DEVELOPMENT REVIEW BOARD
SUPPLEMENTAL SUBMITTAL

PROJECT NO. PR-2019-002411

SUBMITTAL DESCRIPTION: Response to comments including a utility plan with a cross section of trench prisms.

**Development Review Board (DRB)
 Review Comments
 Utility Development Section
 Reviewer: David G. Gutierrez, P.E.
 Phone: 505.289.3307**

PR-2020-002411 SHEET 1 OF 1

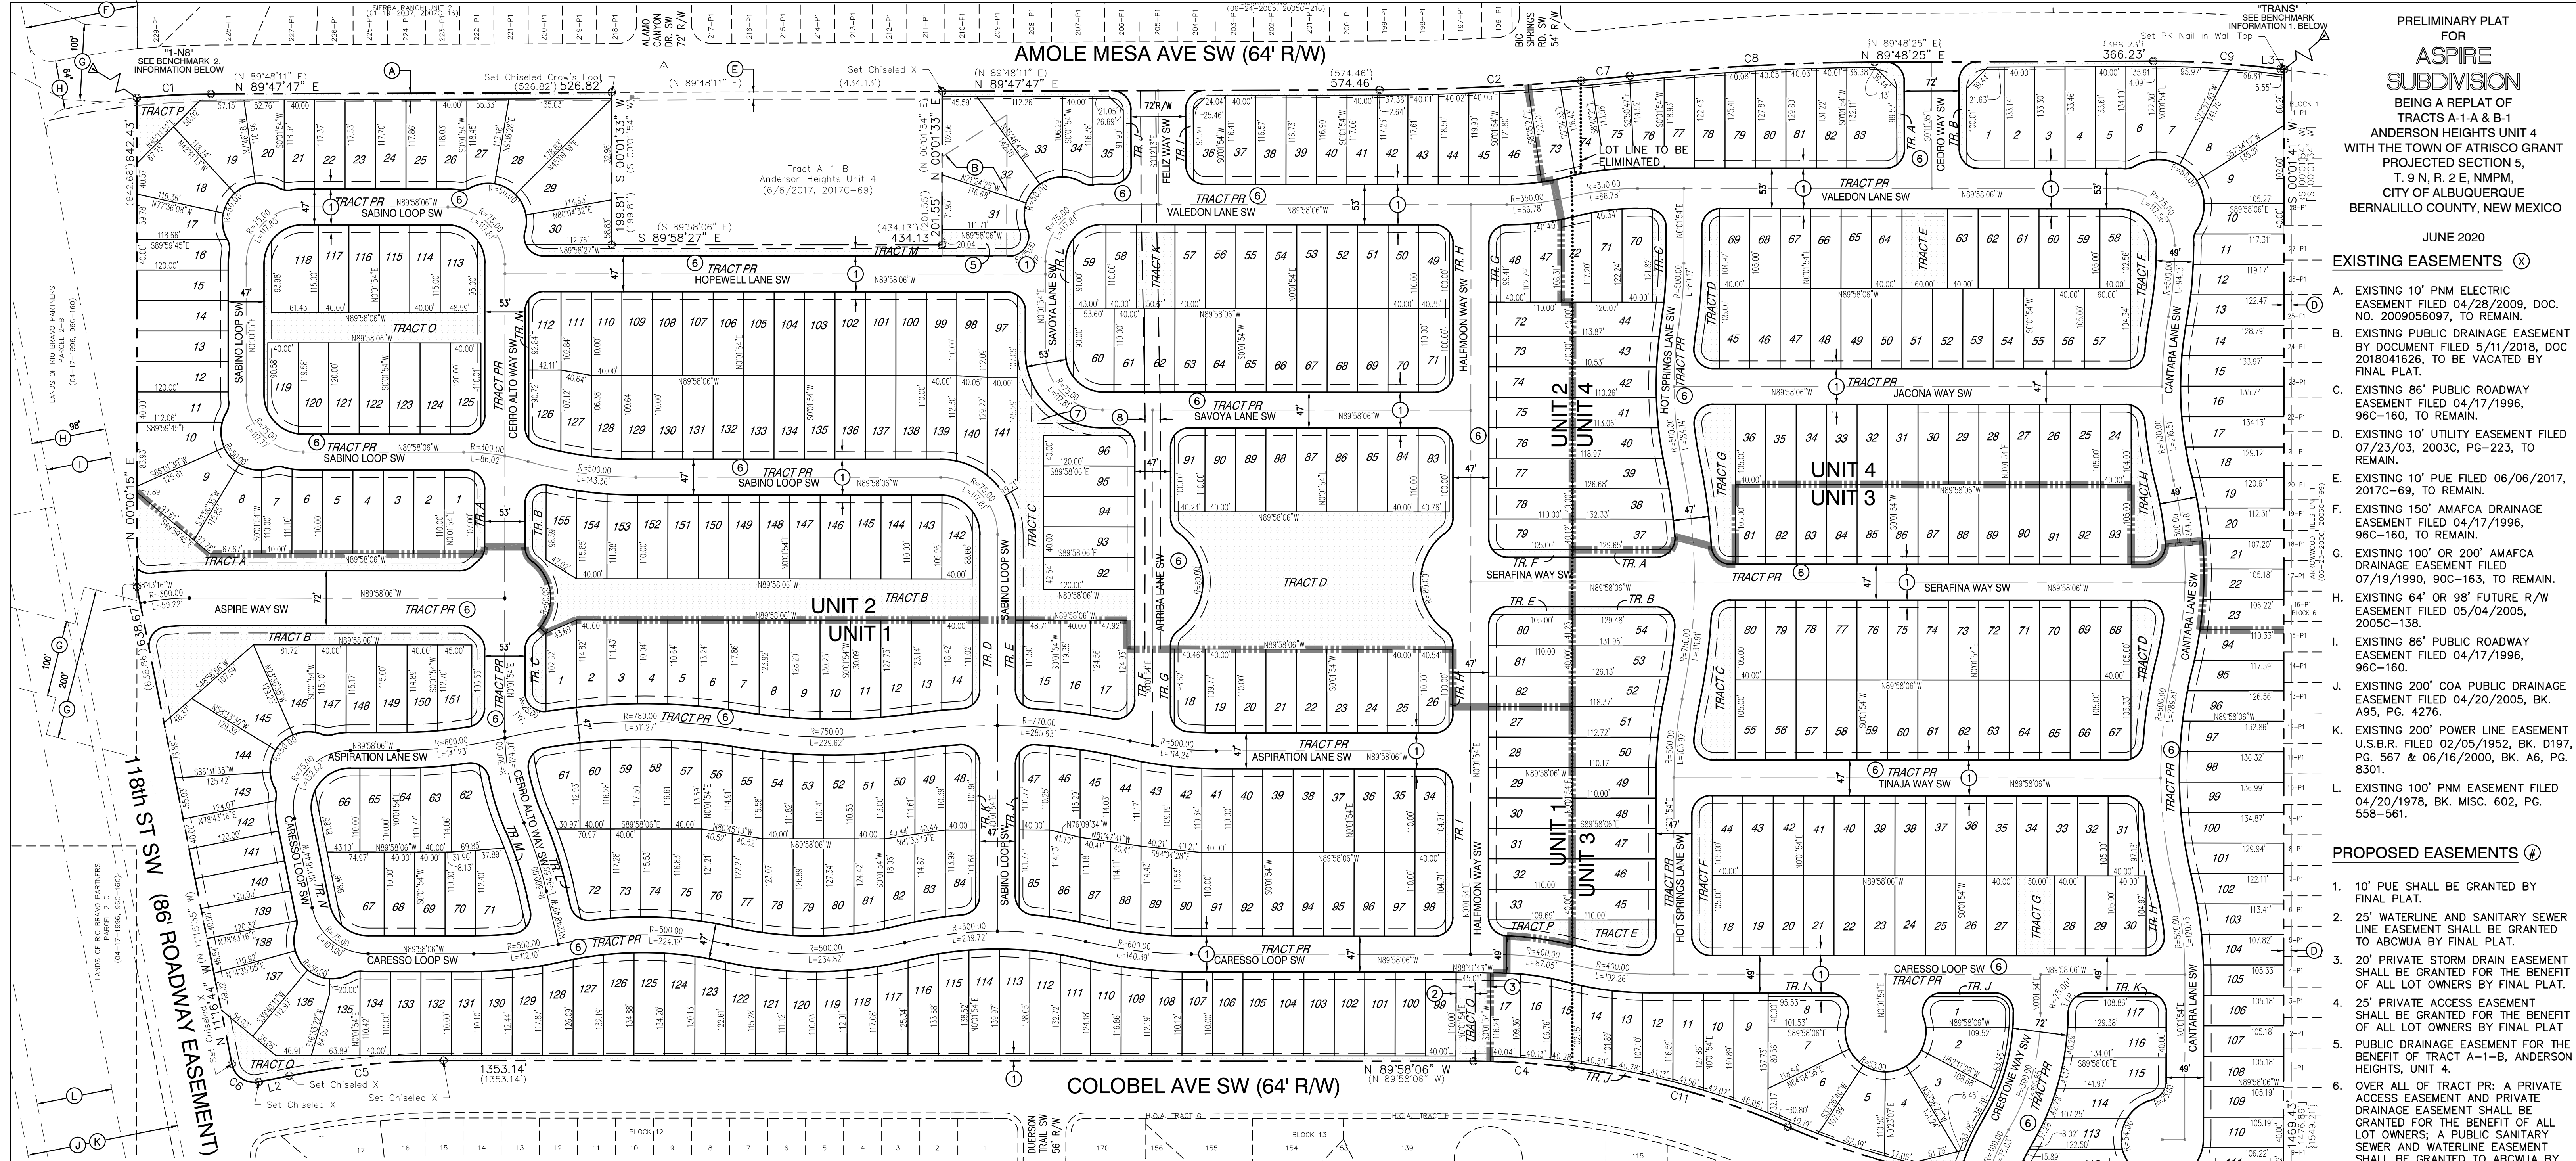
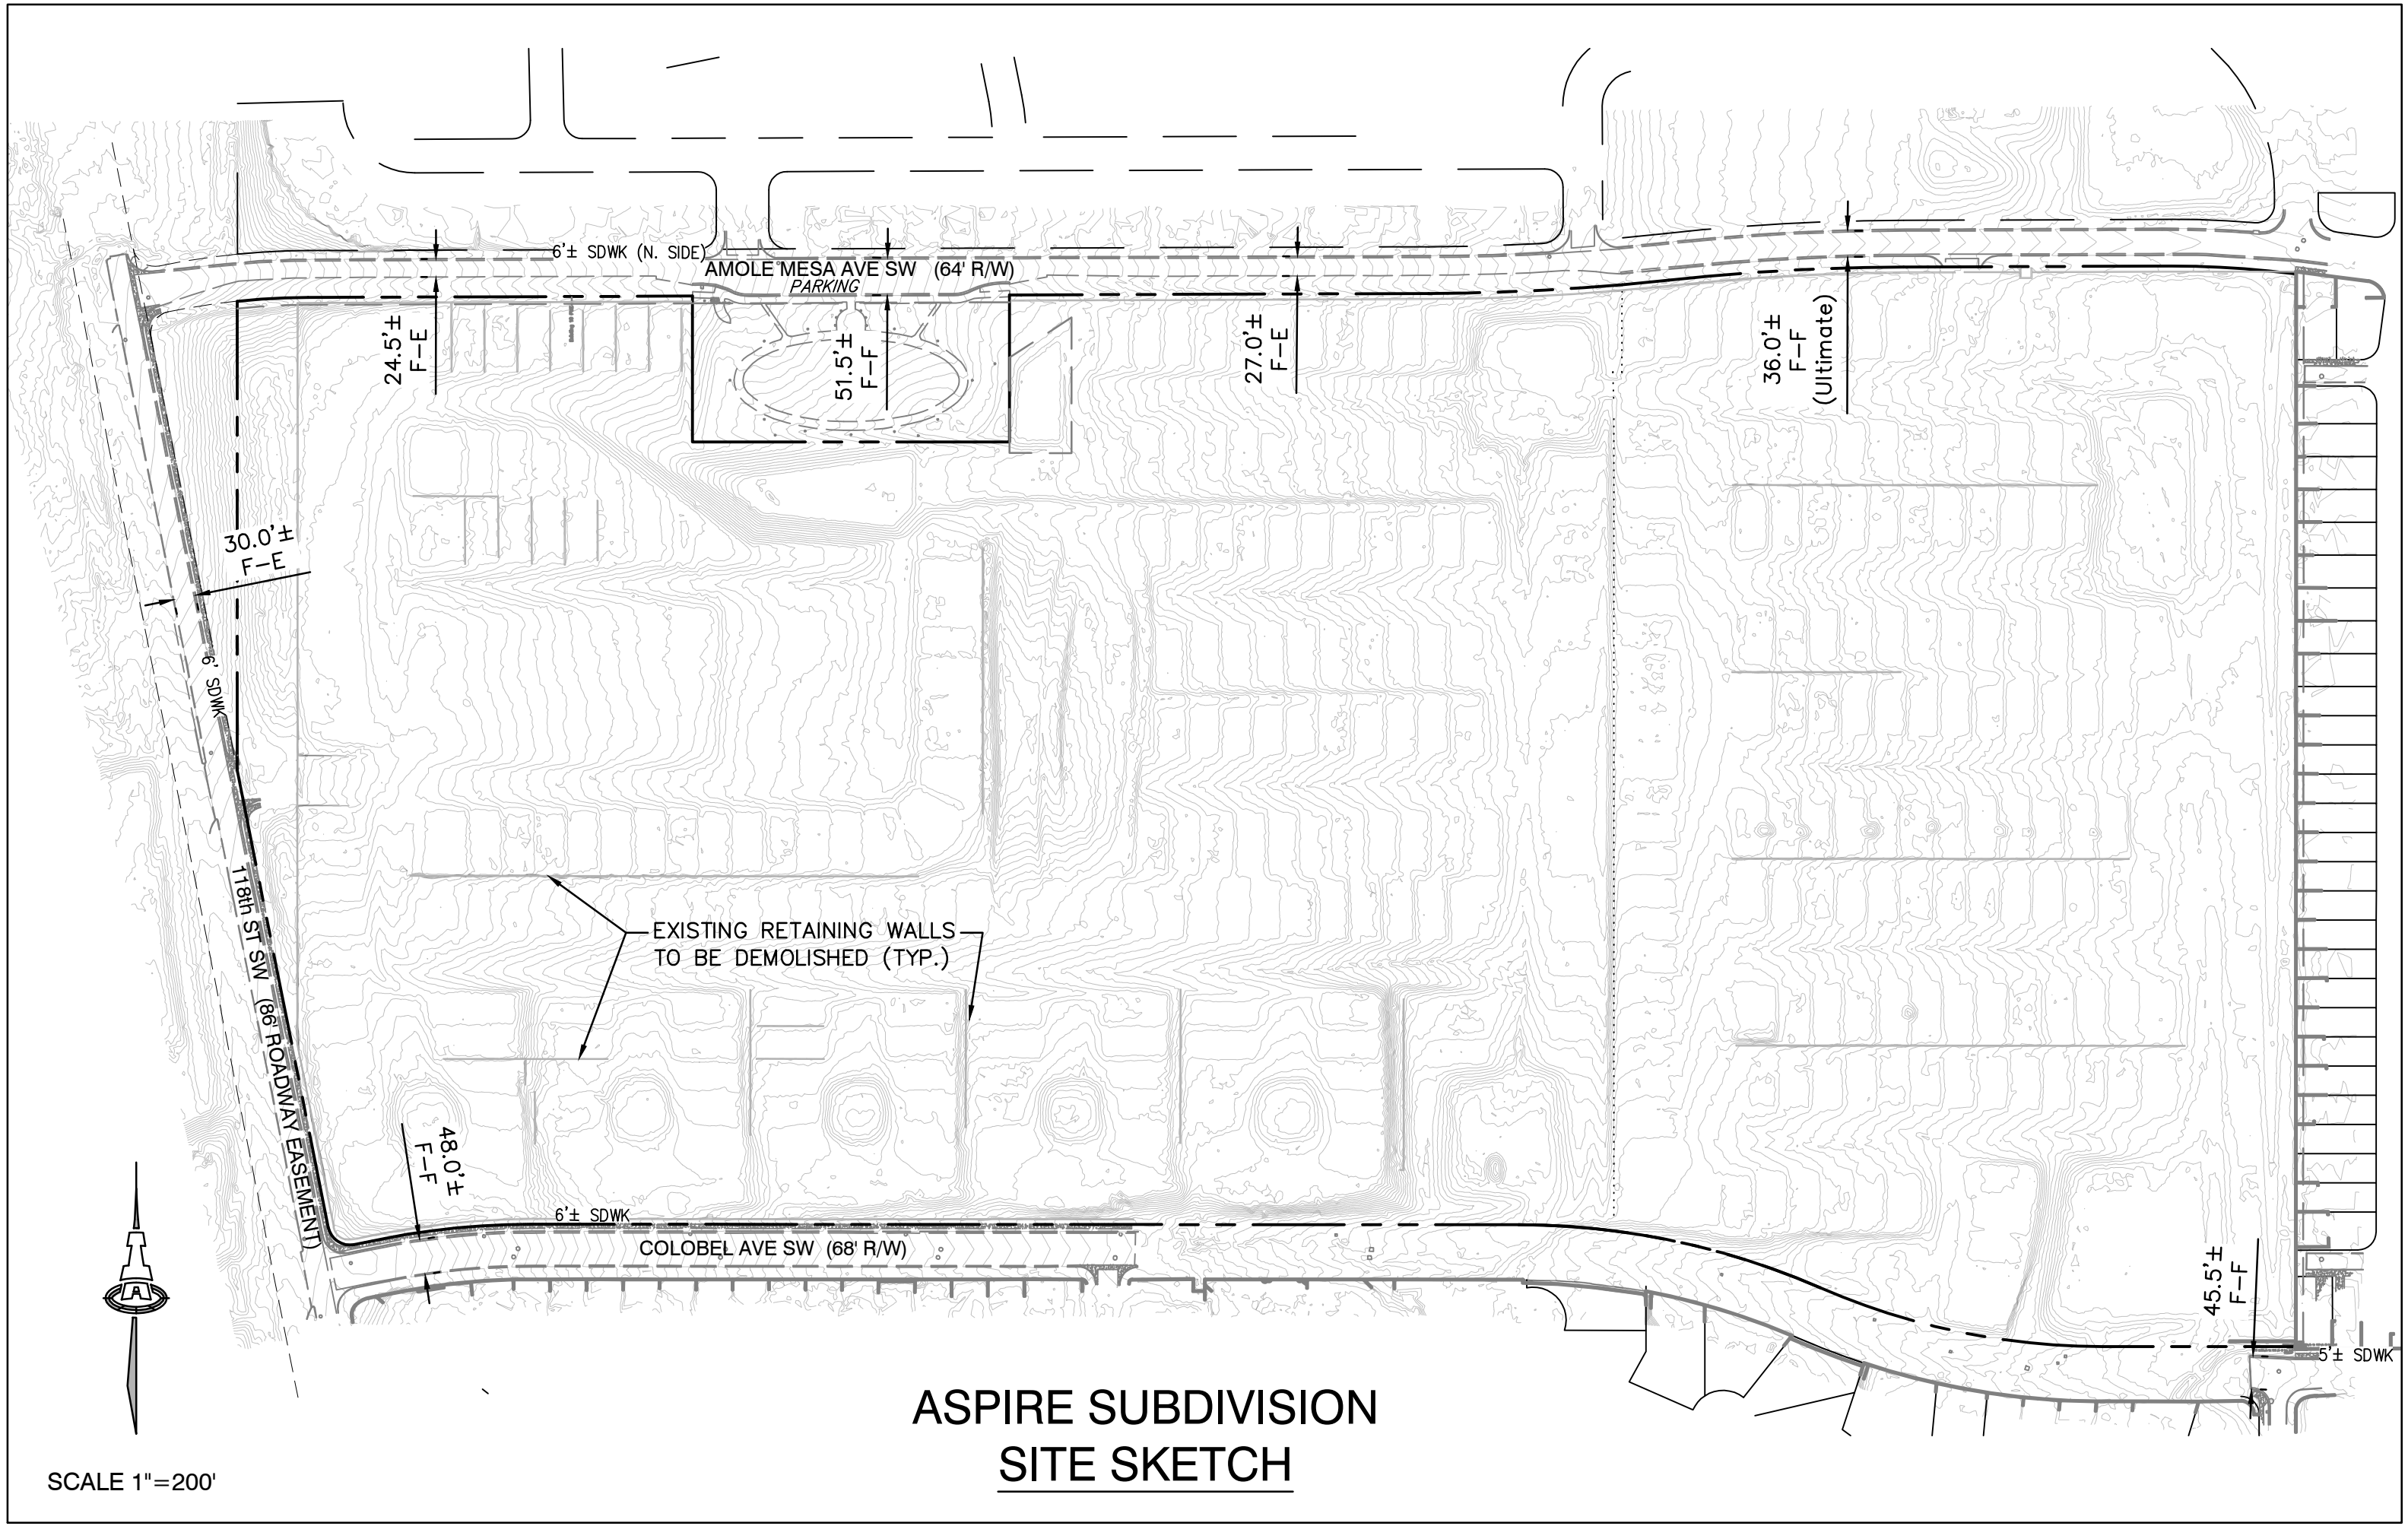
- a. What is the intent of Site Data Note H? It states all water and sanitary sewer services must be verified and coordinated with the Water Authority. The services shall be installed by a project which installs the public waterline and sanitary sewer lines. **That’s a standard note we have always included on the preliminary plats—simply means that we need to coordinate the water and sewer service availability to the project.**
- b. The preliminary plat did not indicate the maintenance and responsibility of proposed Tract O. **Note L. under site data addresses maintenance responsibility for open space tracts. There is also a general note under the easement notes stating that all easements shall be maintained by the HOA. See below.**

- a. Availability statement #200528 provides the conditions for service.
- b. PREVIOUS COMMENT: What is the intent of Site Data Note H? It states all water and sanitary sewer services must be verified and coordinated with the Water Authority. The services shall be installed by a project which installs the public waterline and sanitary sewer lines.
